FW: M/98/25/HH 1 ELMER COURT

Please upload as sub plan for M/98/25/HH as: Proposed Plans and Elevations REV A

Good afternoon Rhiannon
Following up to your message to Jesse Chapman, please find attached a revised drawing that amends the side – east and west – elevations. The elevations now show the correct height to the side panelling.

01 GROUND FLOOR PLAN:

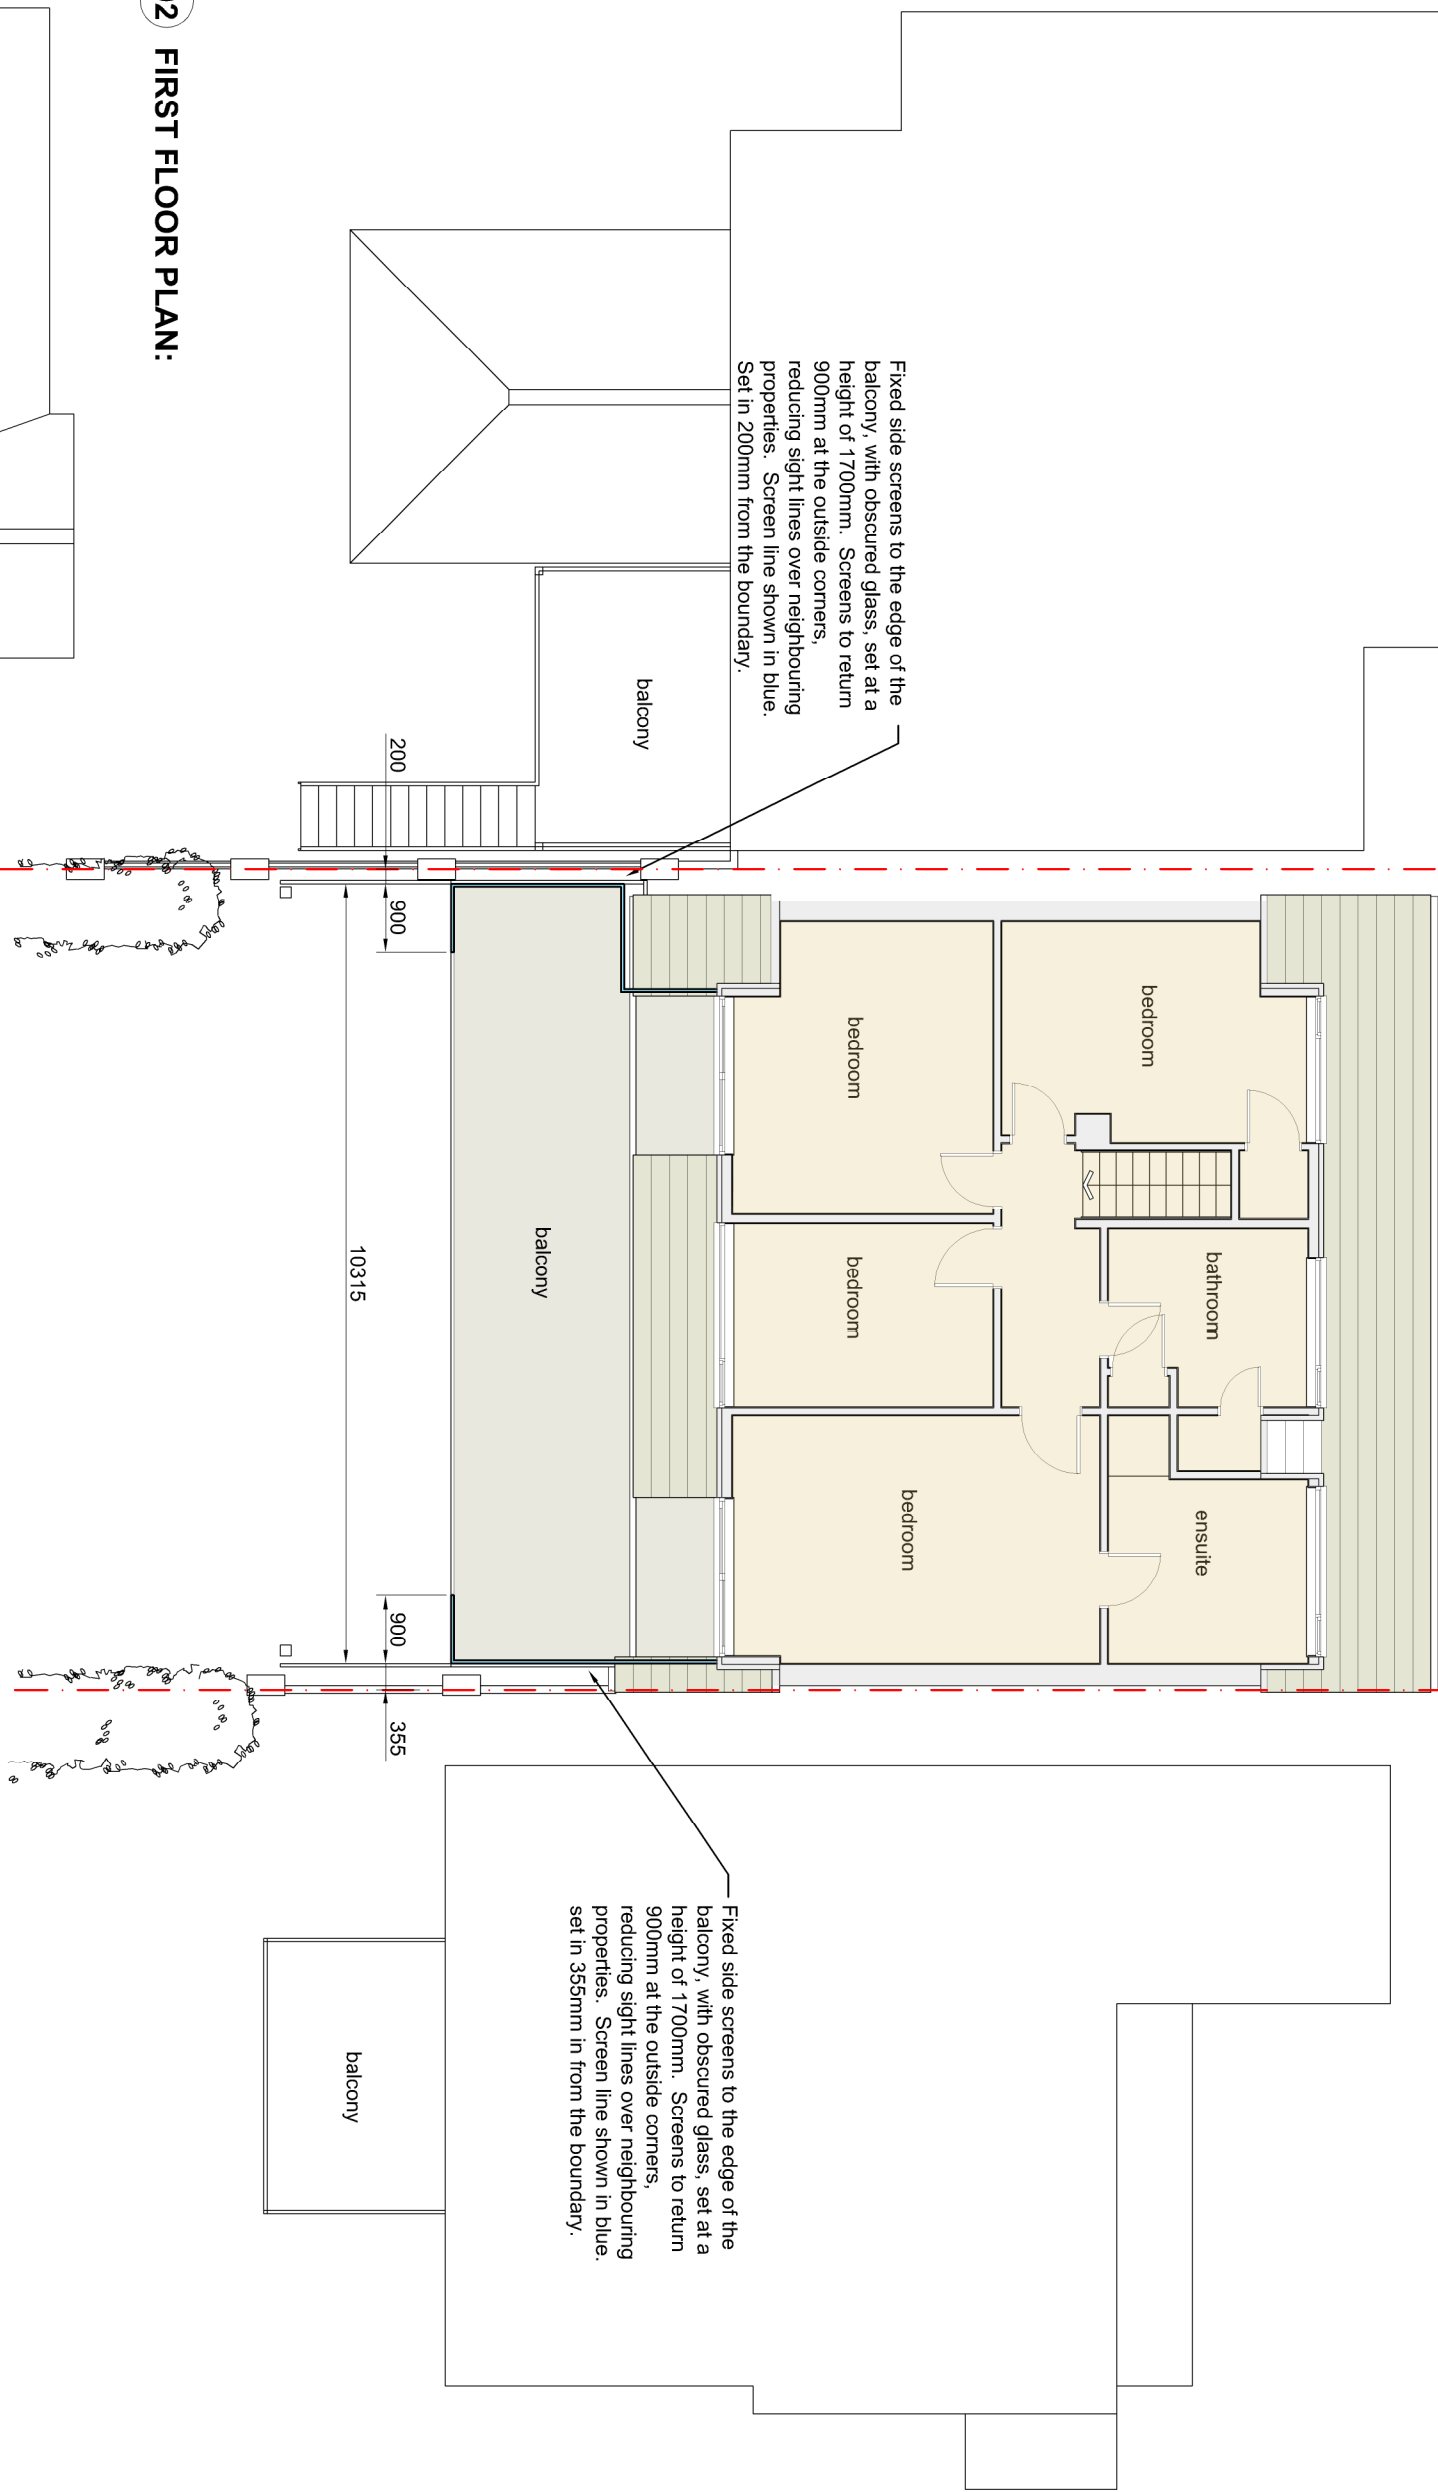
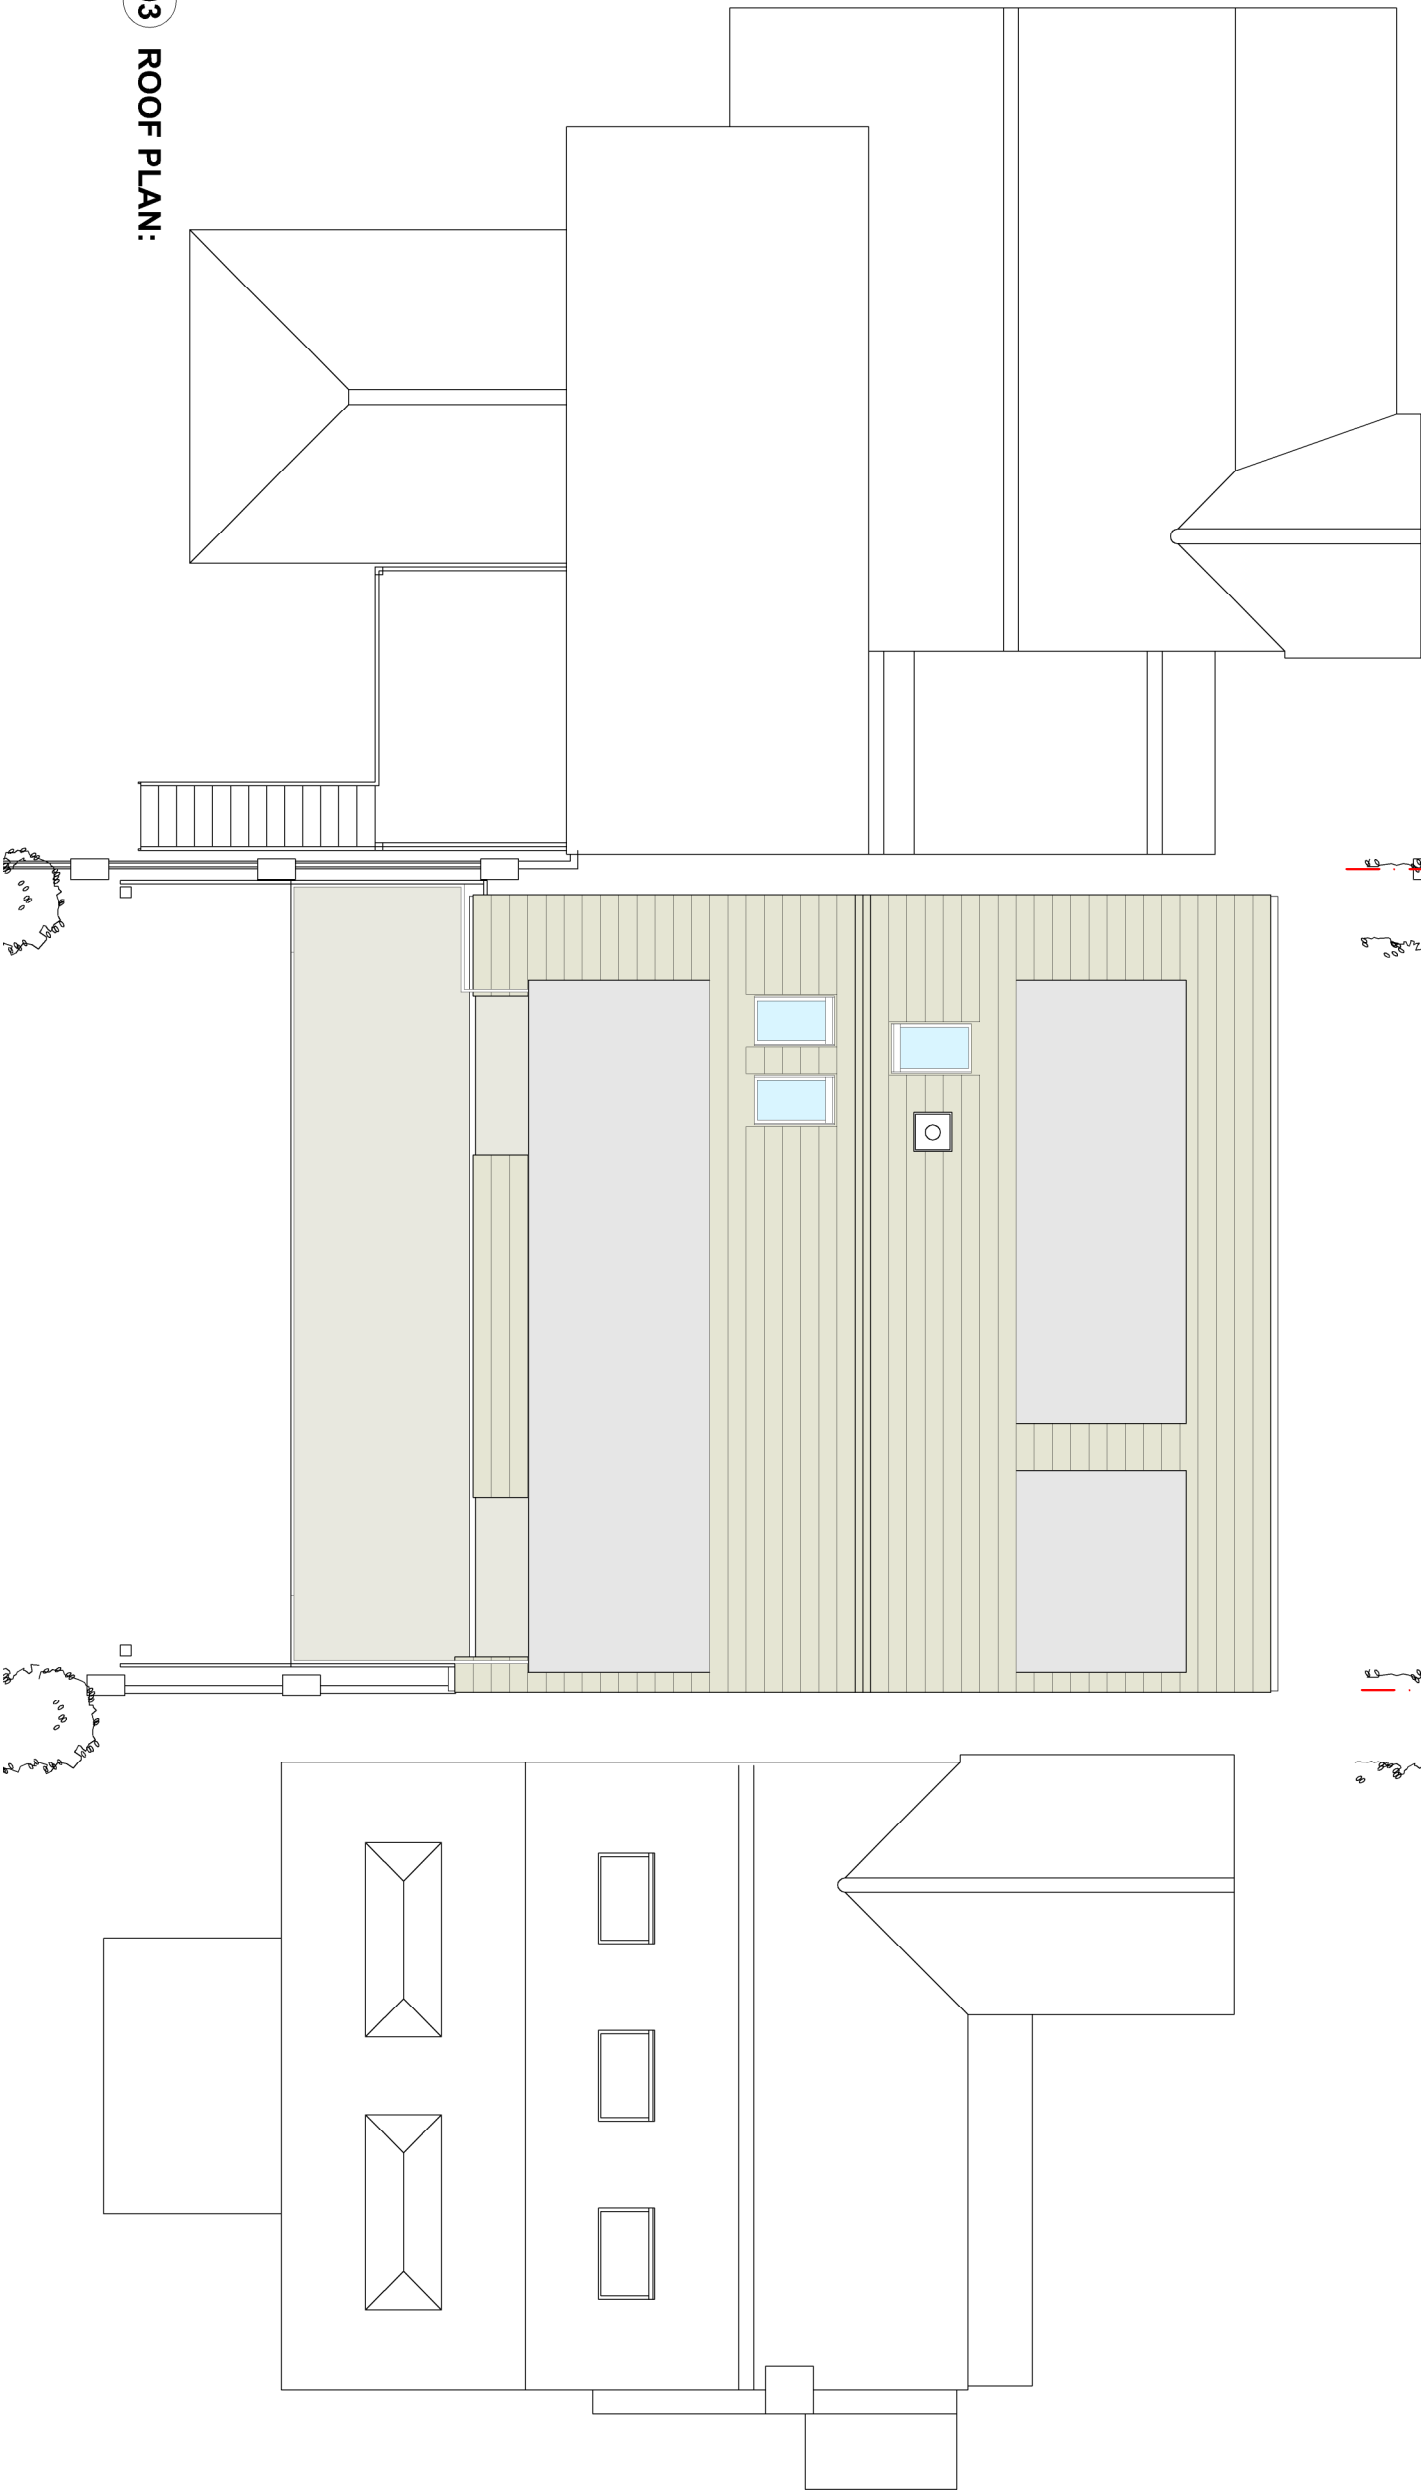
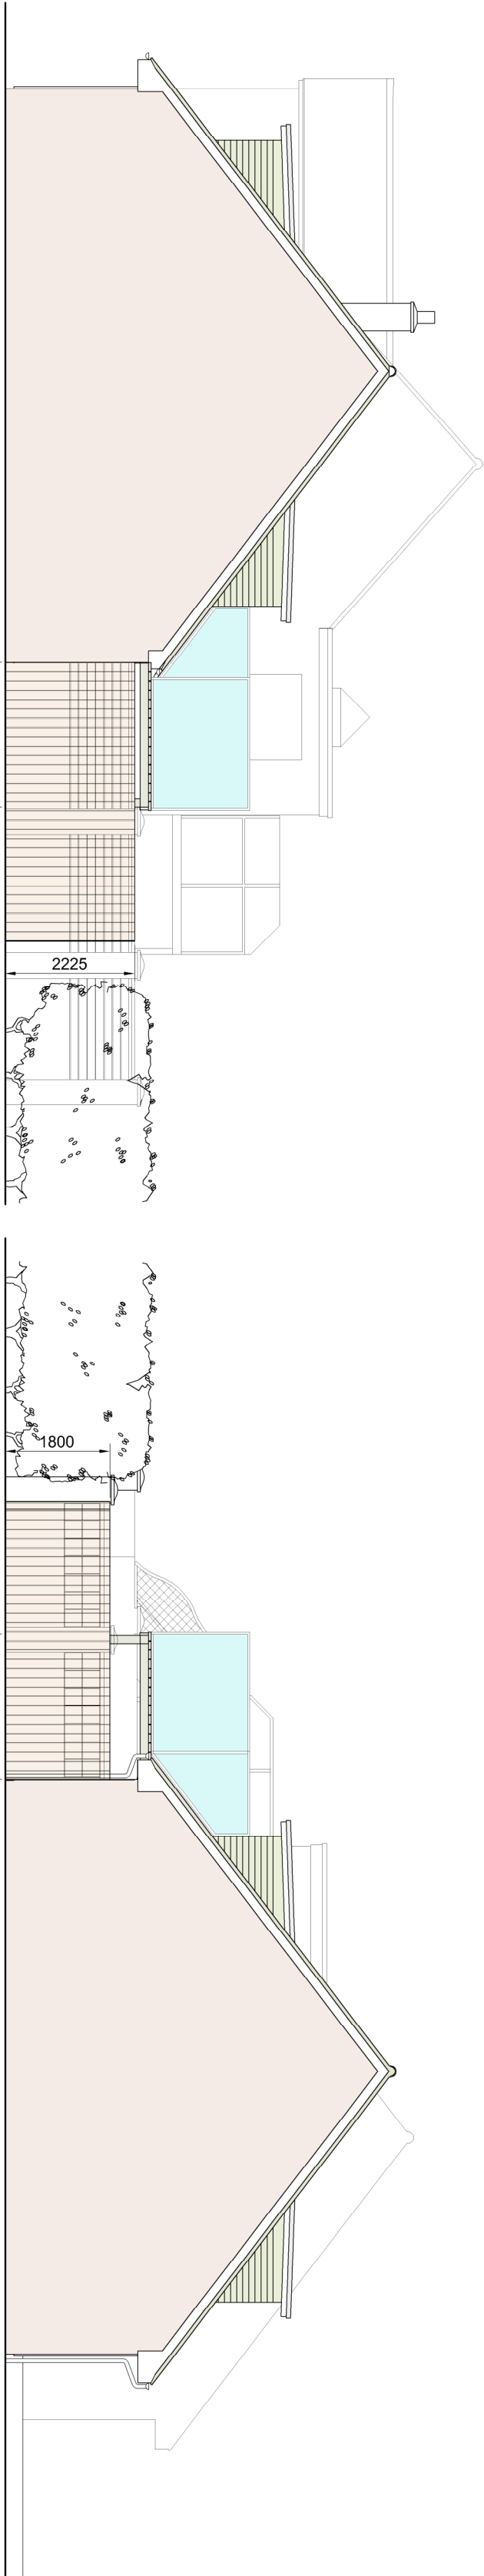
The annotations on the floor plans relating to the fixed side panels appear to be reversed. The east side is labelled as 1.8m, whereas this measurement appears to apply to the west side, and vice versa. As such they do not align with the proposed elevations.

Please could you provide amended plans with the annotations corrected.
